Department of Primary Industries

OUT14/20165

Oberon Timber Complex (DA 27/95 Mod 6) Proposed Modification

Comment by NSW Office of Water

Site Plan

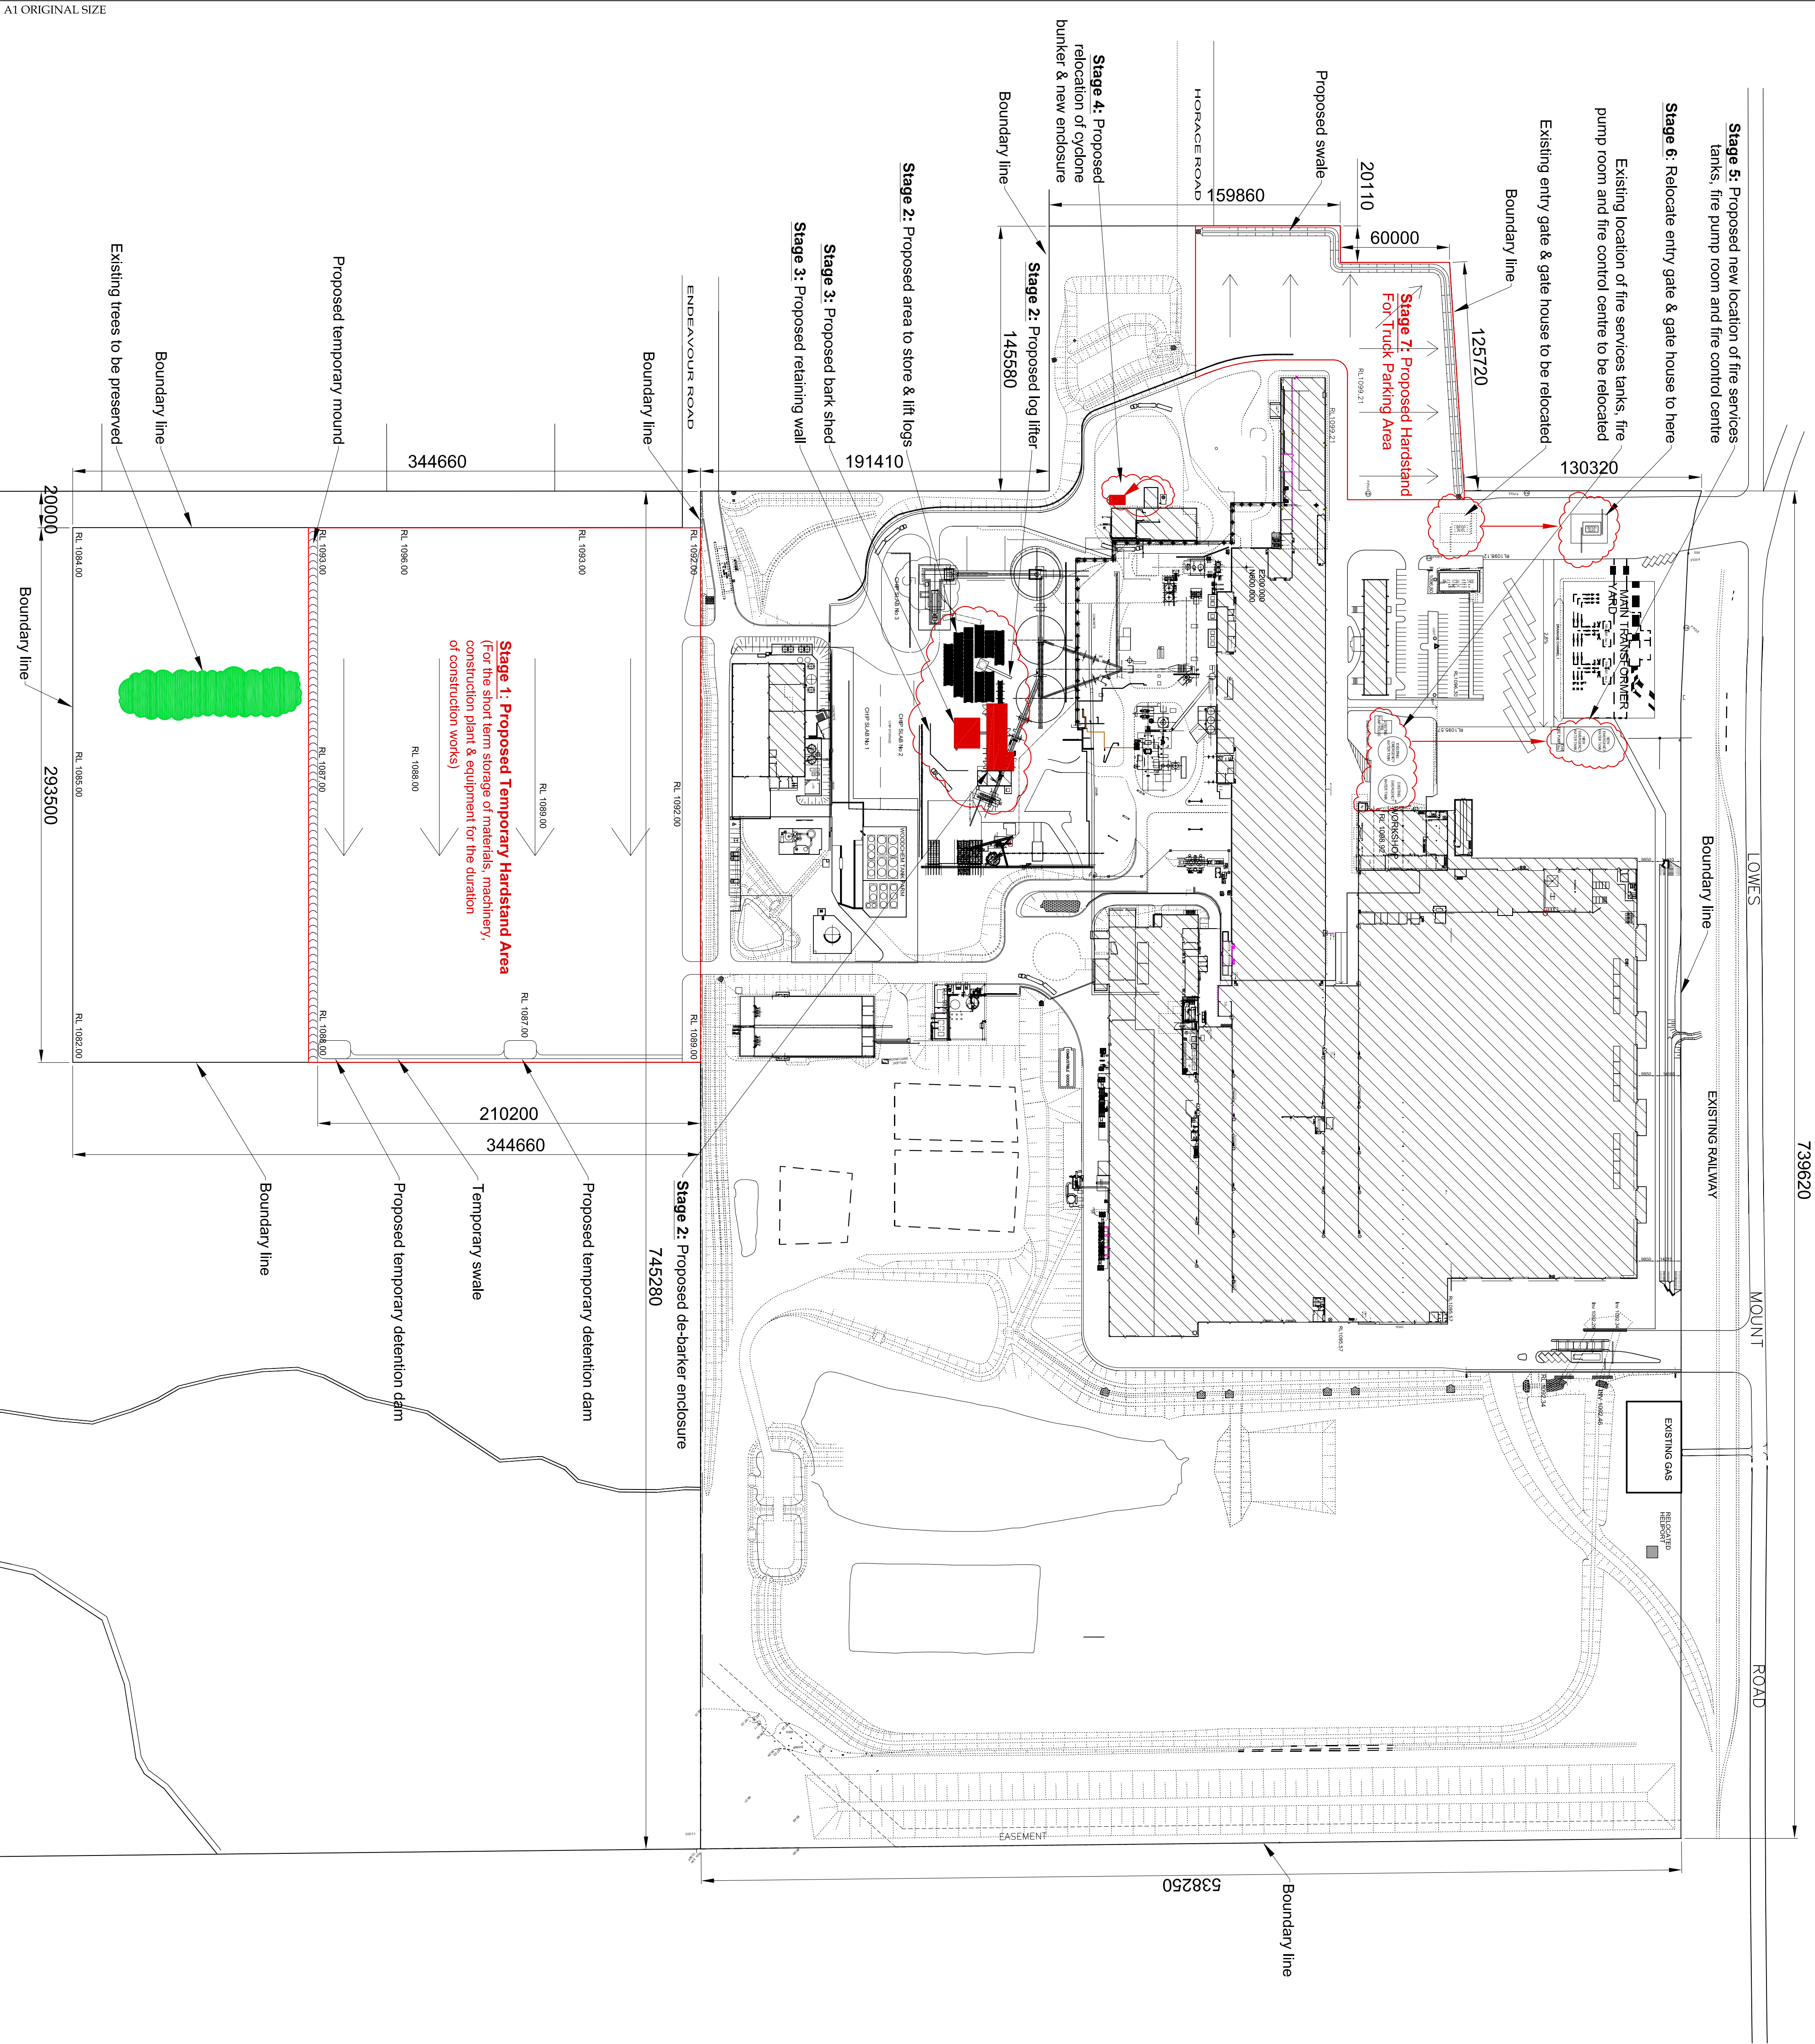
- Section 5.1.2.3 of the EA indicates new wetland/detention areas are proposed, however there are no details for this activity discussed elsewhere in the EA or depicted in the supporting site plans. Clarification is requested on this activity and whether there is additional assessment to support it.
